**KIRKLEES METROPOLITAN COUNCIL
INVESTMENT & REGENERATION SERVICE**

DELEGATED DECISION TO DETERMINE PLANNING APPLICATIONS

Reference No: 2021/62/90279/W

Site Address: 10, Fenay Crescent, Almondbury, Huddersfield, HD5 8XY

Scale	Status
A1 1:100	Planning Submission
Drawn AVR	Checked 5/9/20
Project No. 2020/14	Drawing No. PR01
	Revision G

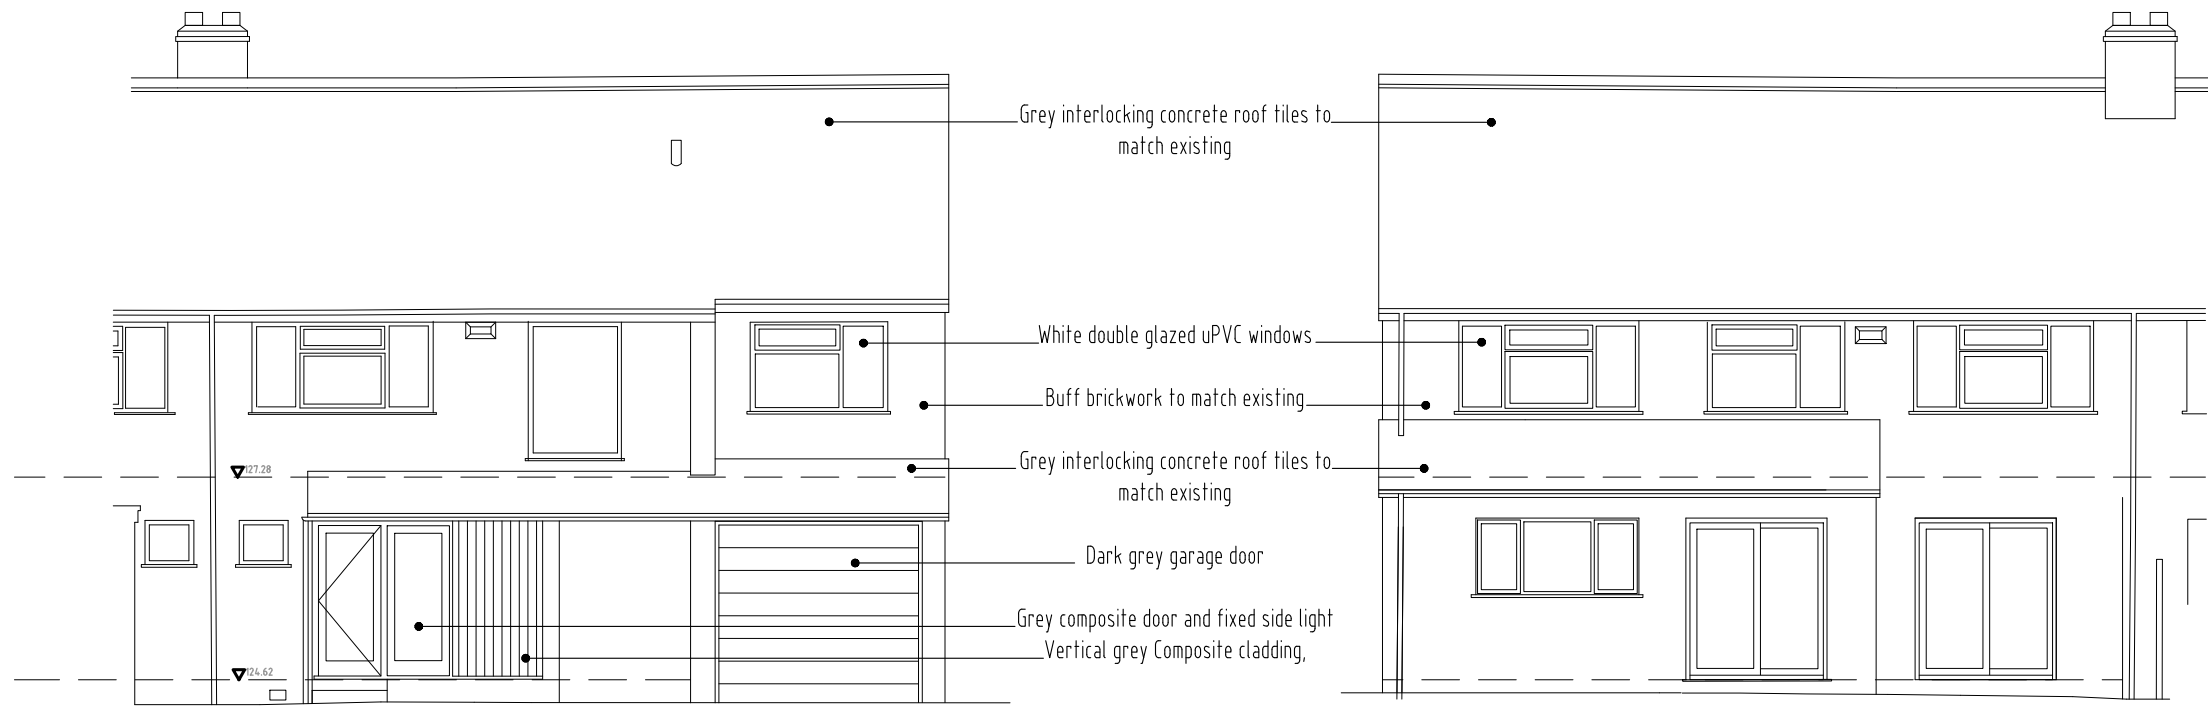
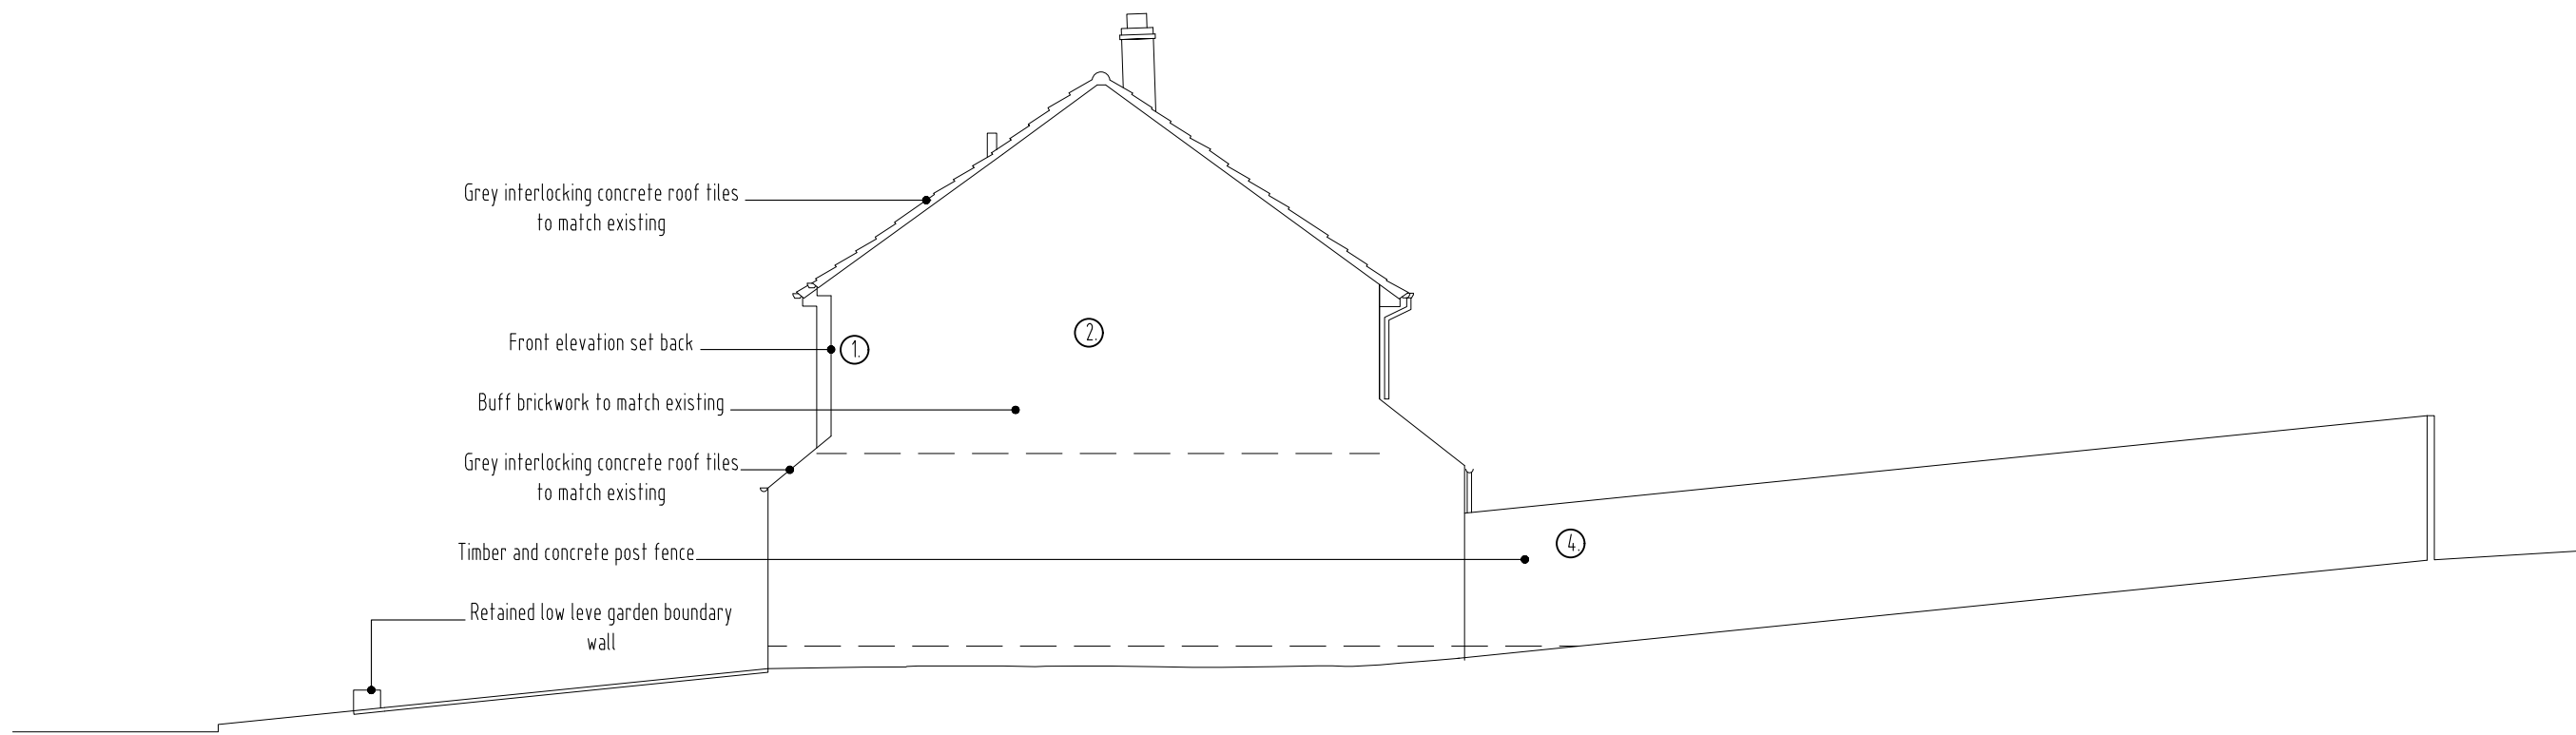
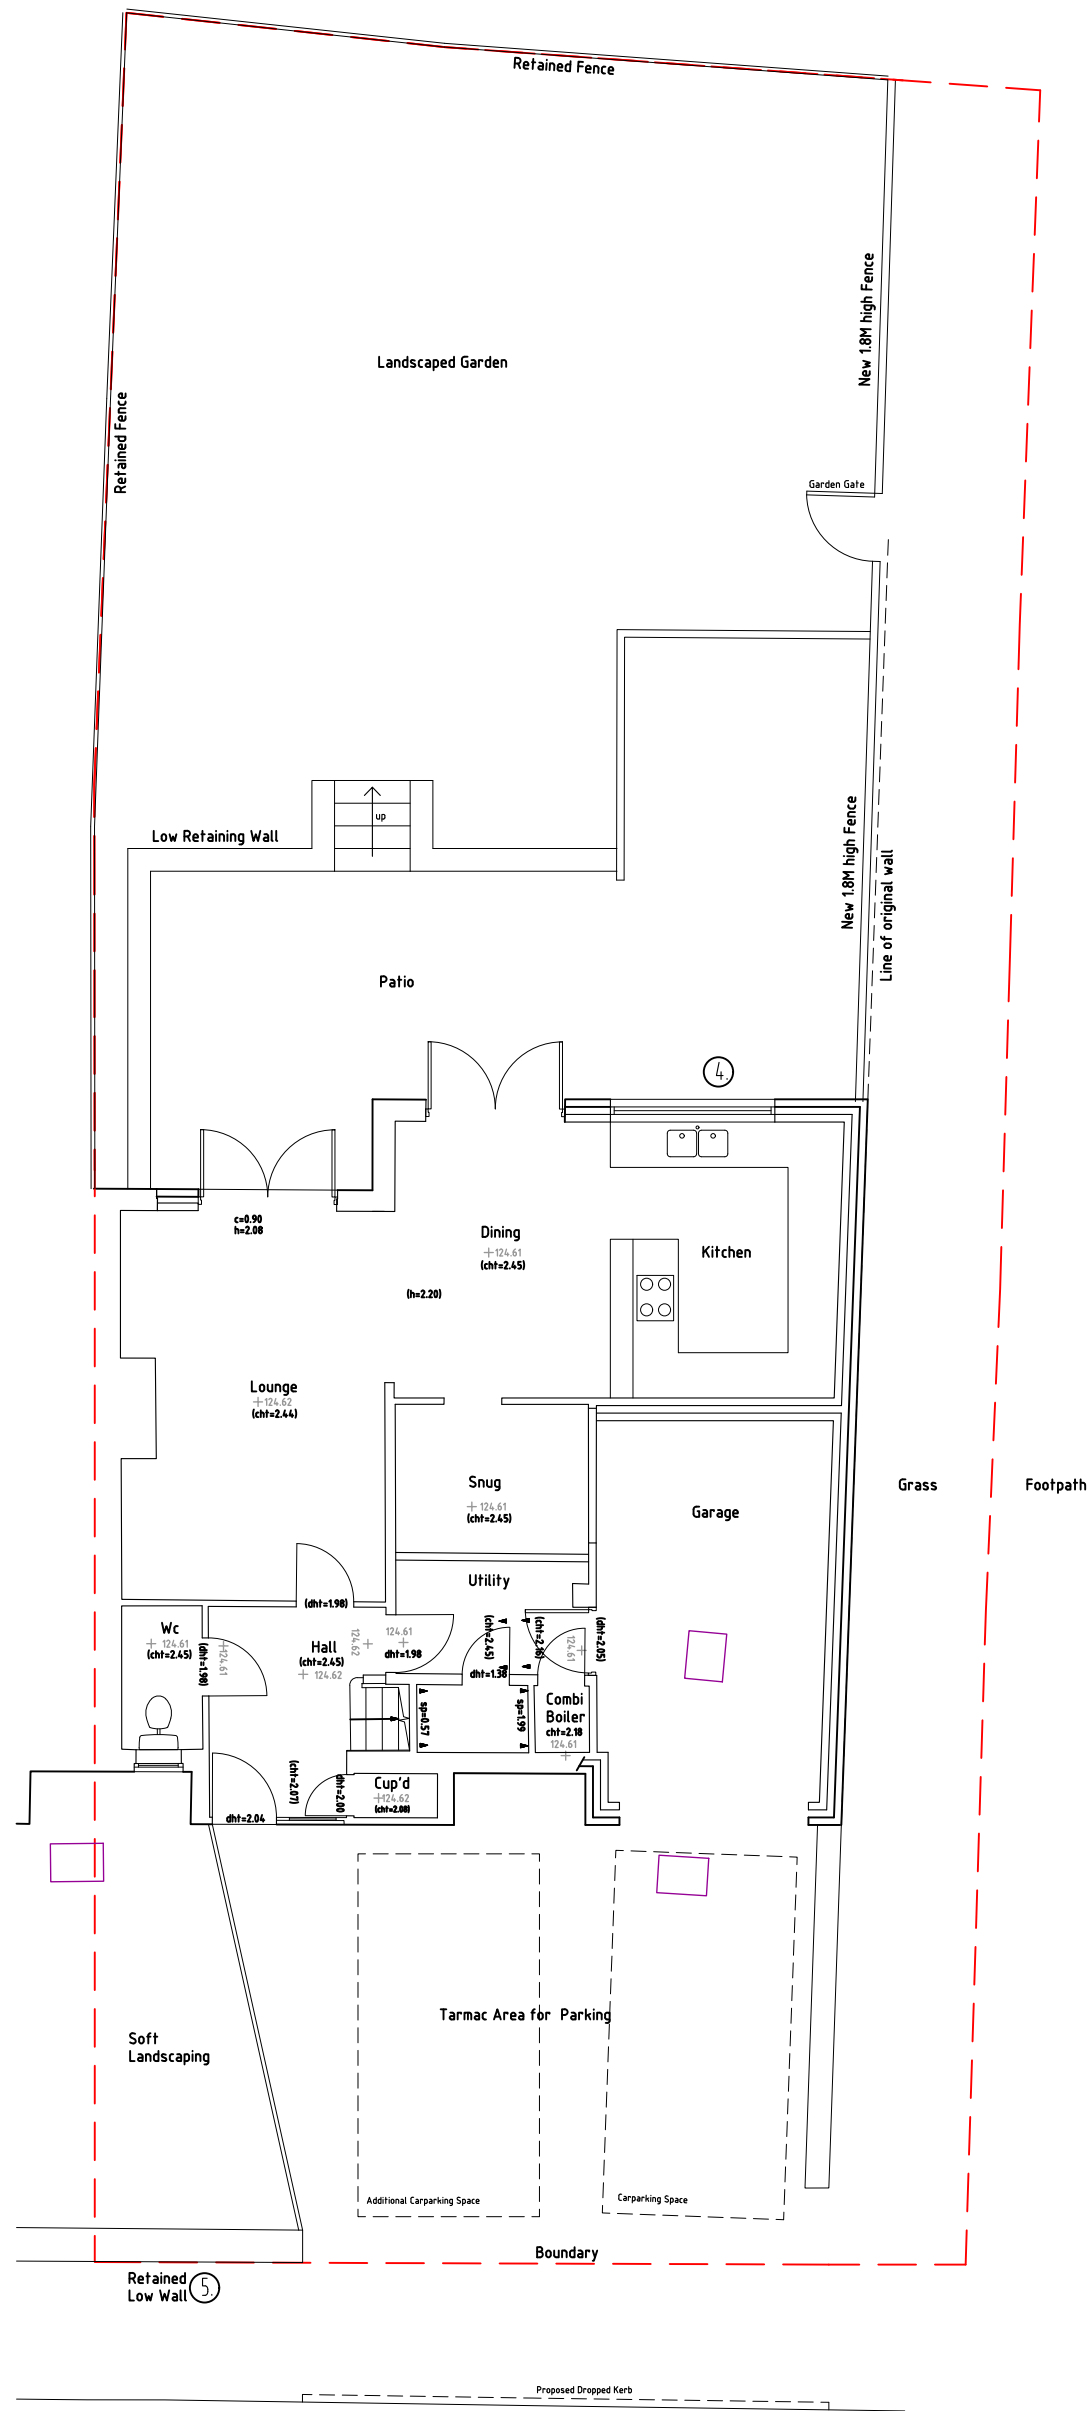
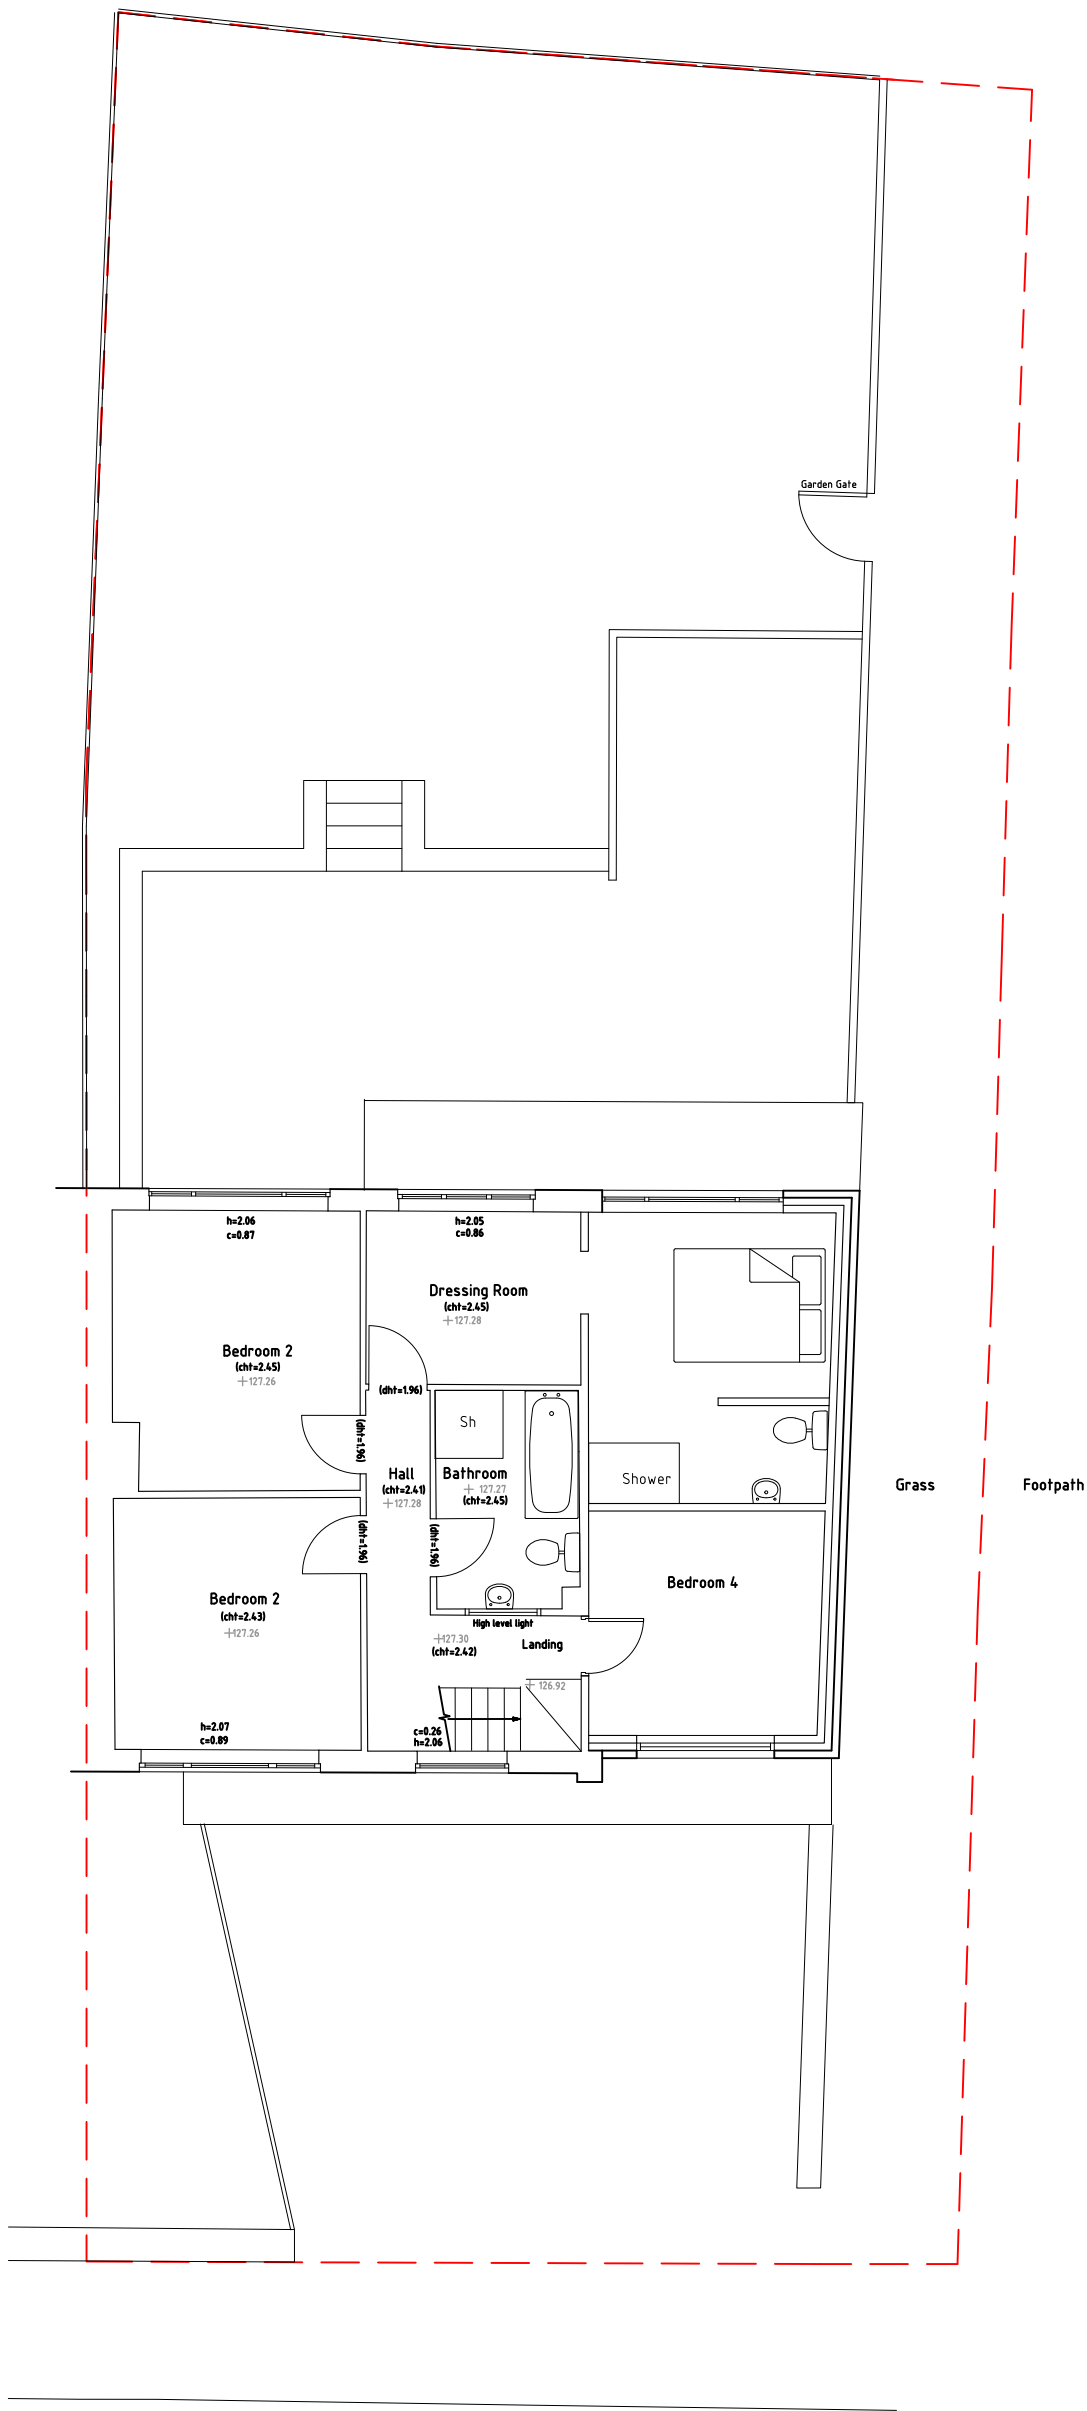
The design of the side extension has been considered acceptable from a visual perspective, as it would follow the simple form of the original property. Its eaves height, roof form and materials will match the host property. The extension would also be set back marginally from the host property, in order to establish its subservience. Whilst officers would prefer the extension to be set down from the ridge roof line, it has been noted that the works would

The submitted information states that the new driveway will be finished in tarmac, however, officers would like to see this aspect being laid in a permeable surface and therefore more details will be provided within the later of this report.

In this case, officers have noted that a second parking space will be provided on the driveway to the front of the dwelling, alongside an integral garage. With regards to the garage, this unfortunately would only have a length of 5.1m and therefore would be below standard. However, this is still likely to be suitable for a small car.

4. The extended driveway as indicated on the approved floor plan Dwg no. PR01 Rev G shall be laid out with a hardened and drained surface in accordance with the Communities and Local Government; and Environment Agency's 'Guidance on the permeable surfacing of front gardens (parking areas)' published 13th May 2009 (ISBN 9781409804864) as amended or any successor guidance; Notwithstanding the provisions of the Town and Country Planning (General Permitted Development) (England) Order 2015 as amended (or any Order revoking or re-enacting that Order) this shall be so retained, free of obstructions and available for parking.
